**re: Grading, Servicing and Landscape Plan Review**  
Proposed Commercial Building  
30 Auriga Drive - Ottawa, Ontario

**date:** May 12, 2023

**file:** PG6513-MEMO.01

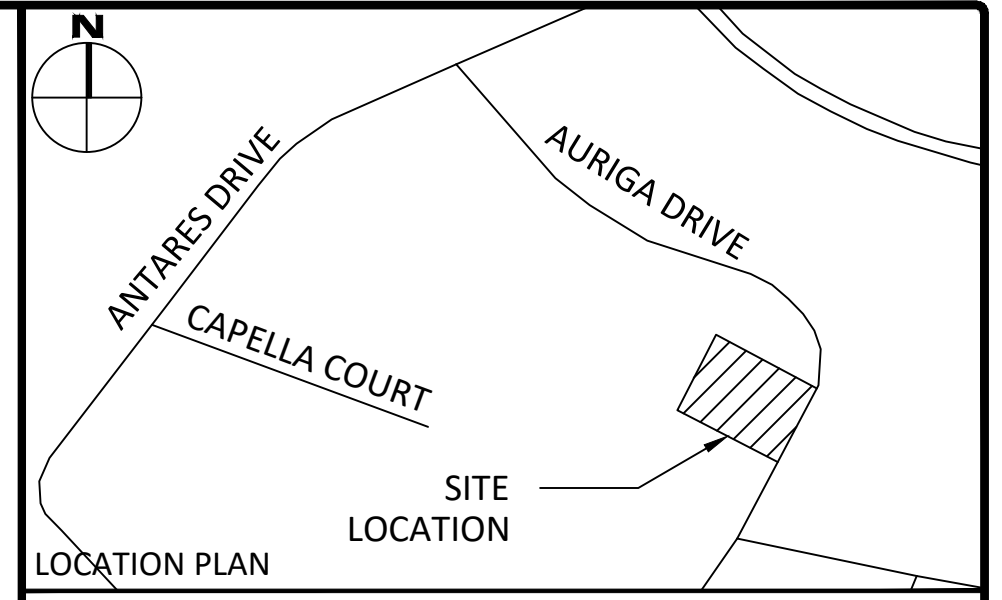
In reviewing the Site Servicing Plan, referenced above, most of the proposed services have sufficient frost cover. However, insufficient frost protection has been provided to certain storm services, where highlighted on the attached plan. Insulation of the site servicing is recommended where insufficient frost cover has been provided. Our detailed frost protection recommendations are provided below and on the attached plan.

Any portion of the proposed sewer services installed at a depth of 2.1 m below finished grade, or deeper, is considered to have sufficient soil cover for frost protection. However, based on our review, some of the proposed storm services and their subgrades are anticipated to be founded within the frost zone. Where insufficient soil cover is present above the obvert of the pipe, the following frost protection criteria should be followed:

Thermal Condition	Soil Cover Provided D (mm)	Insulation Dimensions (mm)	
		t (thickness)	L (extension)
Unheated	Less than 1,100	Not Recommended	
	1,100 to 1,400	75	Extend 900 mm horizontally beyond edge face of the sewer
	1,400 to 1,700	50	Extend 600 mm horizontally beyond edge face of the sewer
	1,700 to 2,000	25	Extend 300 mm horizontally beyond edge face of the sewer

All rigid insulation should consist of either Dow Chemical High-Load 40 (HI-40), Styro Rail SR.P400, or equivalent approved by Paterson. The placement of all insulation within the service trenches must be reviewed and approved by Paterson personnel at the time of construction.
